## **HINCKLEY NATIONAL RAIL FREIGHT INTERCHANGE**

### **The Hinckley National Rail Freight Interchange Development Consent Order**

### **Applicant's response to Deadline 6 Submissions [part 6- Statutory Bodies]**

Document reference: 18.20

M69-A47 LINK ROAD GENERAL ARRANGEMENT

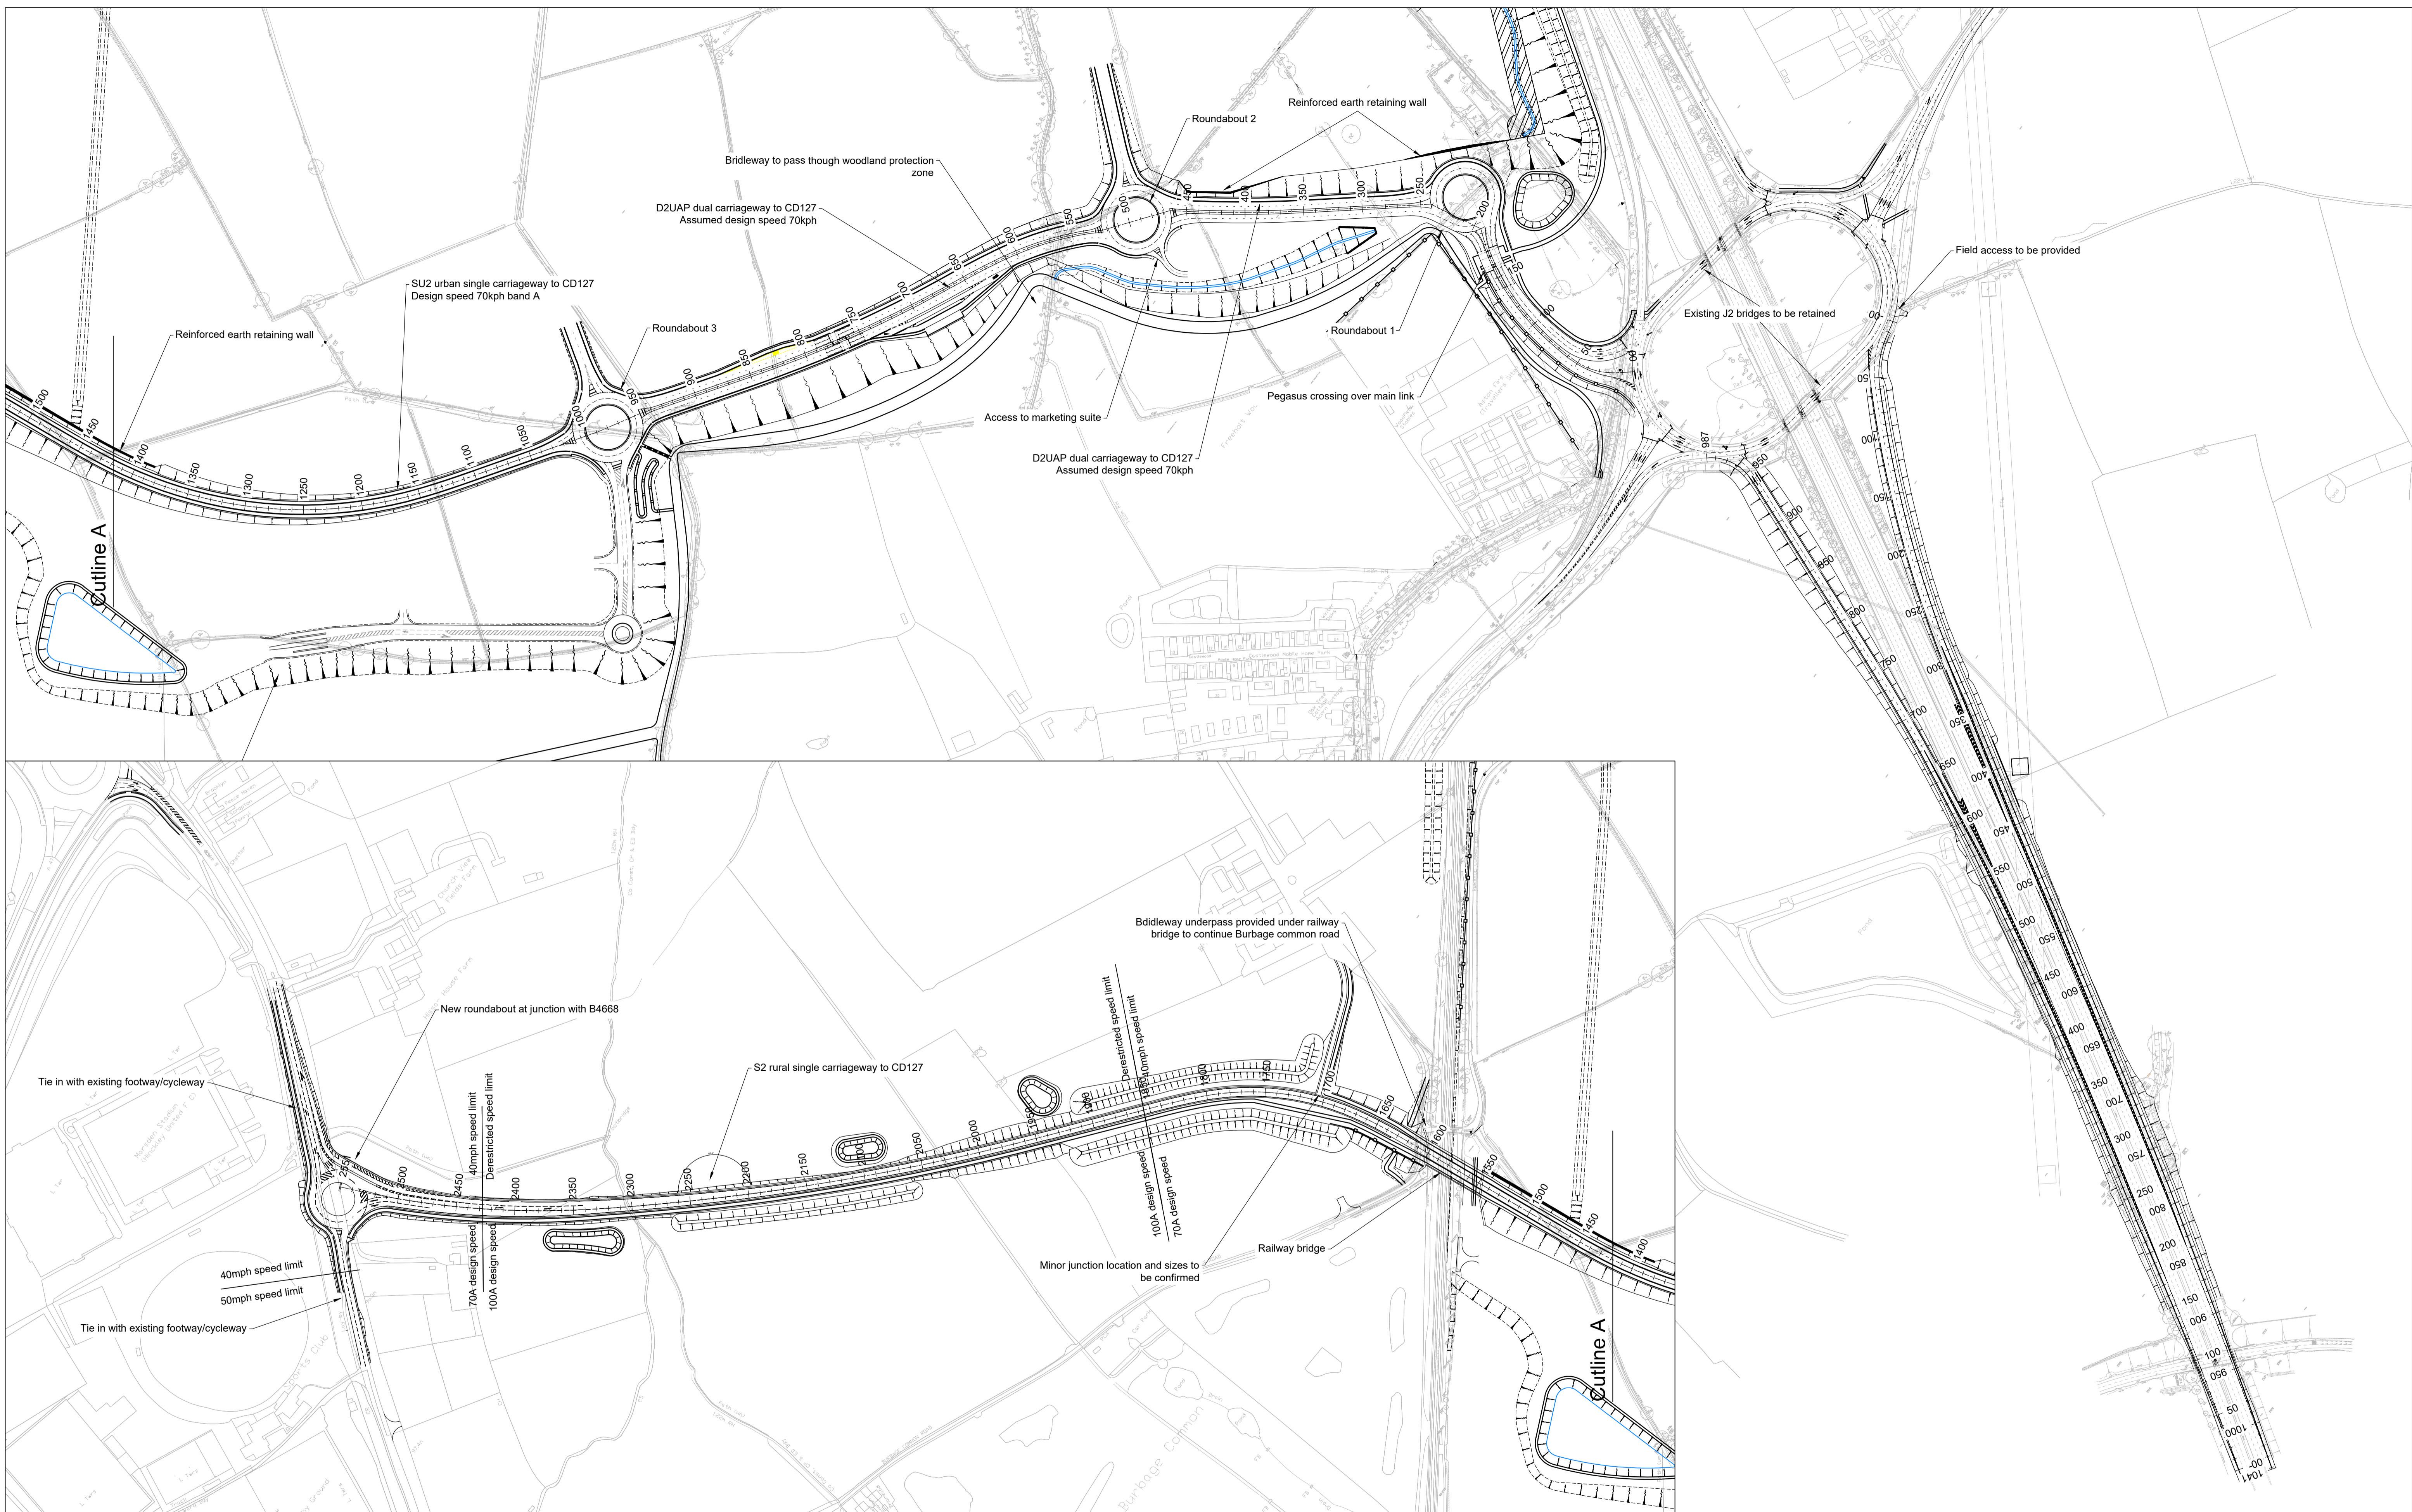
<b>HNRFI Works Plans (Document Ref: 2.4H)</b>		
11	National Highways notes that updated Works Plans have been submitted. However, as per our previous position, the suitability of all proposals can only be confirmed following agreement of traffic modelling work which remains ongoing.	Noted- extensive remodelling has taken place on the basis of requirements from the Highway Authorities to include 2023 observed traffic.
<b>Applicants' response to deadline 3 submissions (Appendix B - Transport 2023 Update) (Document Ref: 18.13.2)</b>		
12	National Highways notes that the Appendices to the Transport update of 2023 has been submitted. This includes all significant volume (in excess of 1,000 pages) of modelling outputs reports. Whilst not all these would relate to the SRN, National Highways will, nonetheless, require additional time to review these. It should also be noted that the final review of these can only be possible once traffic input flows (relating to the PRTM and furnessing matters) are resolved.	The submission documentation contained furnished traffic data based on the more robust 2018 flow information. At the request of the Highway Authorities, the Applicant had to re-survey and re-model all the mitigation and SRN junctions based on 2023 flows. This meant a very large volume of work being done in December and Early January. All of which broadly reach the same conclusions.
